Rezoning Transportation Analysis

Petition Number: 2021-160

Revision Log:

| Date | Description |
|------------|--------------------|
| 11-22-2021 | Fourth Review (WB) |

○ **Entrance Road (Community House Road to Roundabout)**
N.T.S.

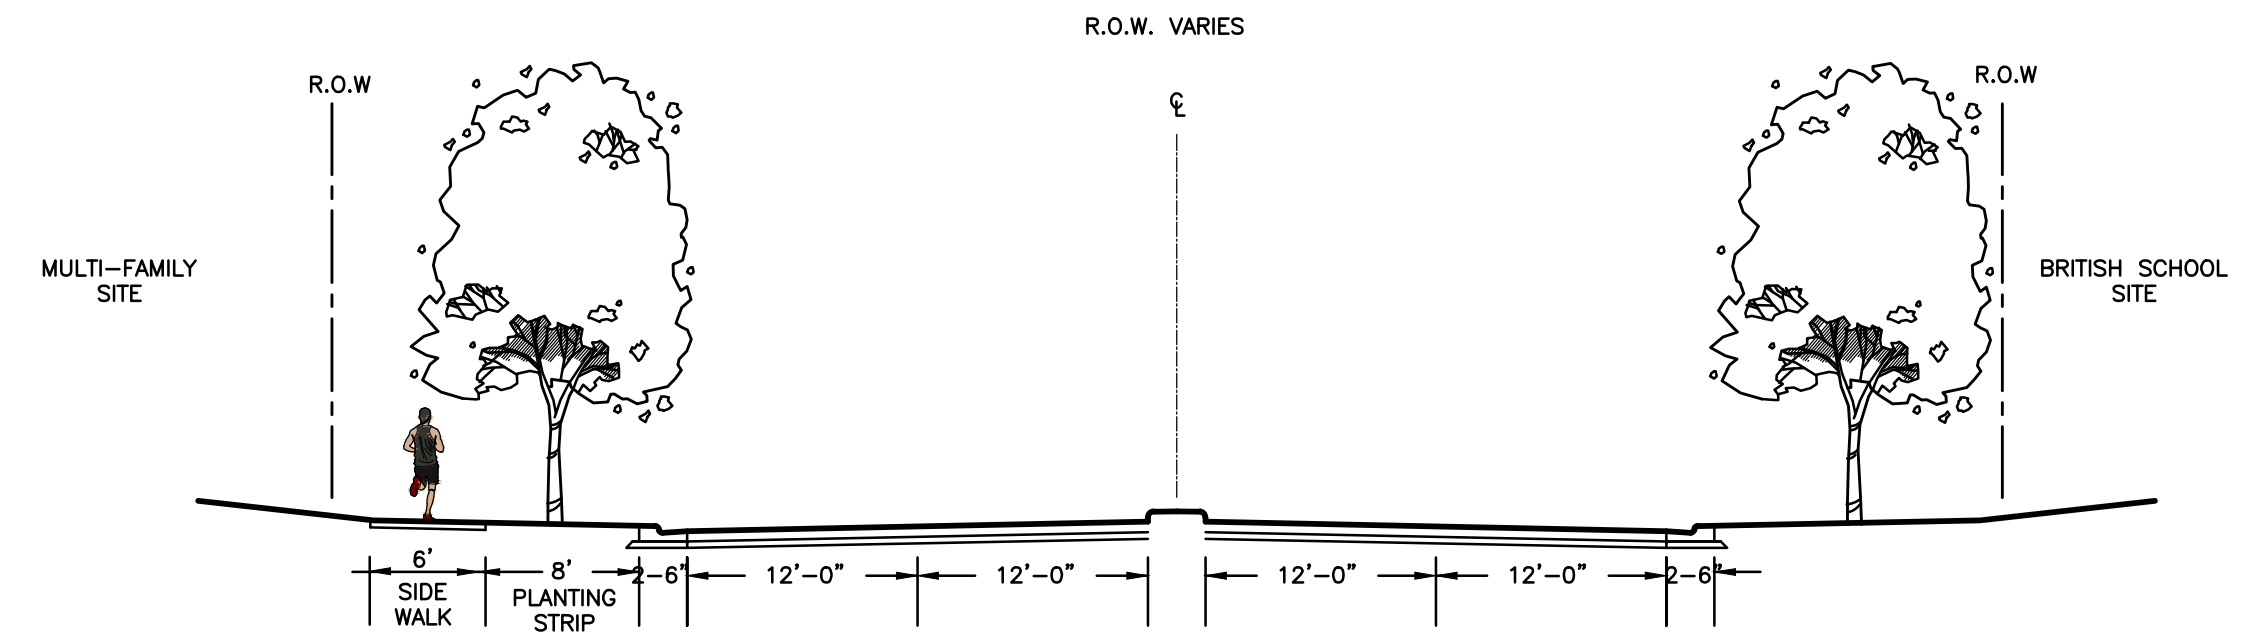
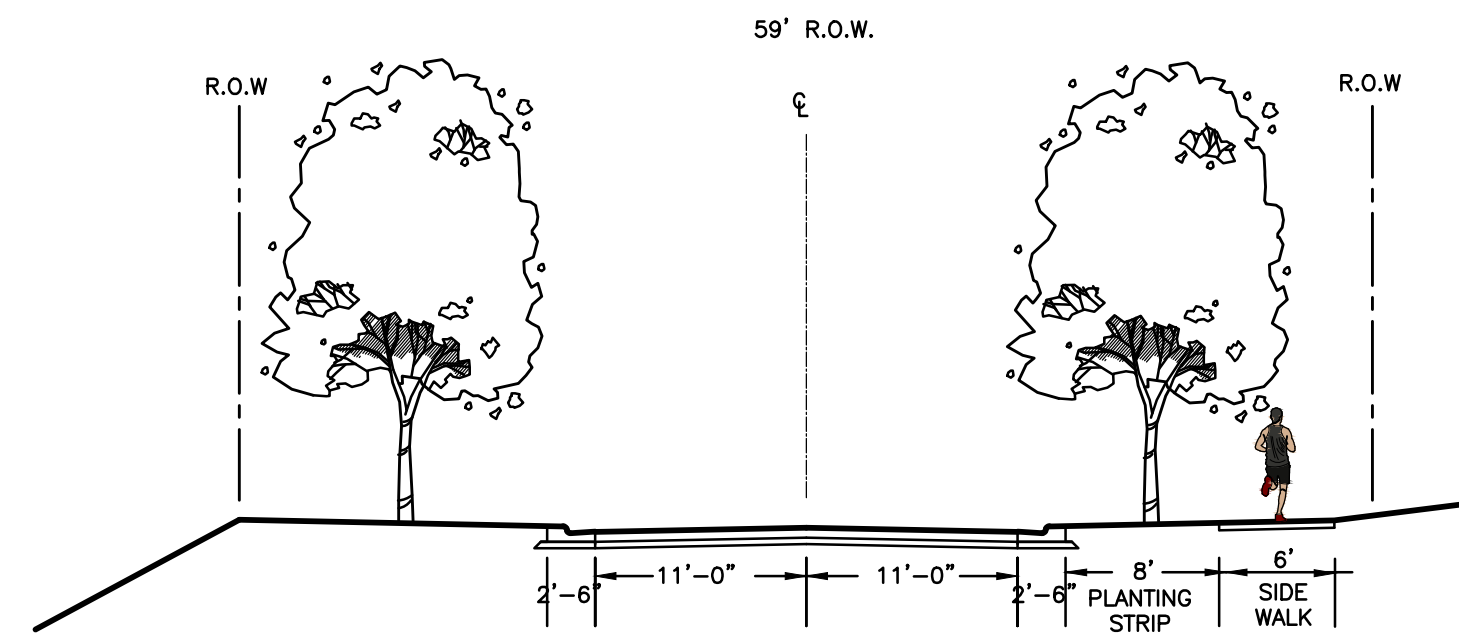
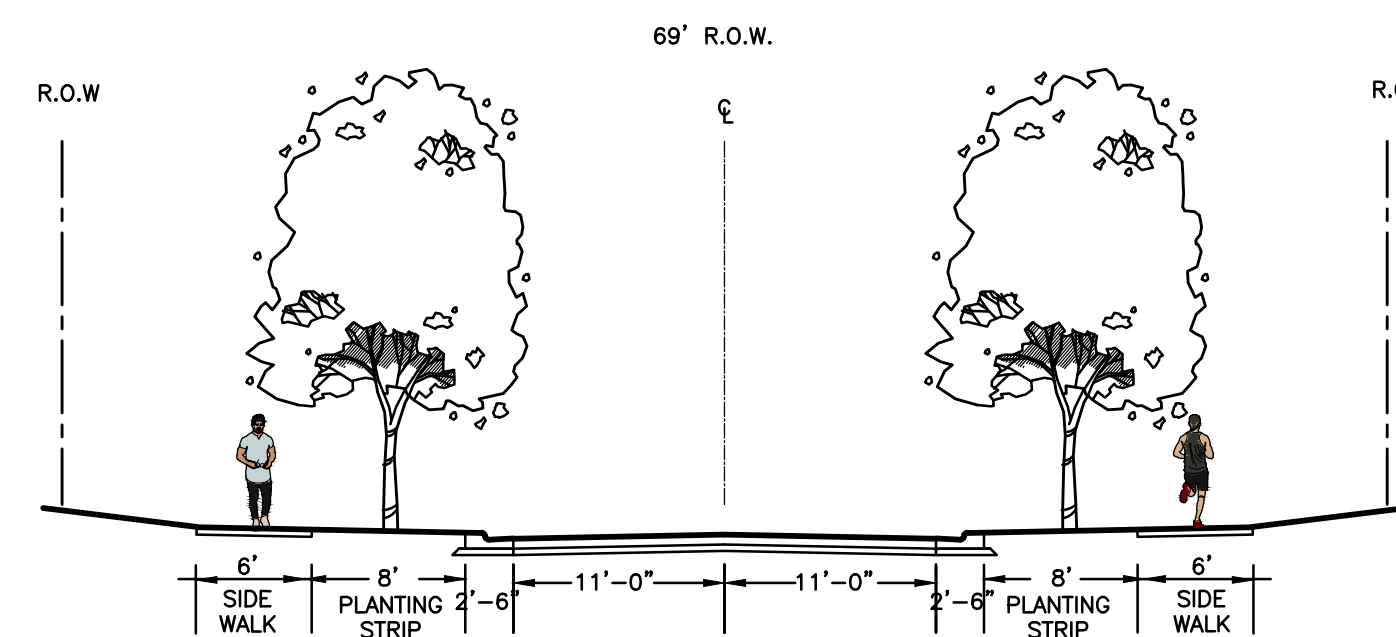
Revise site plan and conditional note(s) to commit to installing accessible curb ramps at every intersection per PROWAG and ADA law. The site plan shall label and dimension both items from the back of curb and gutter and road centerline.
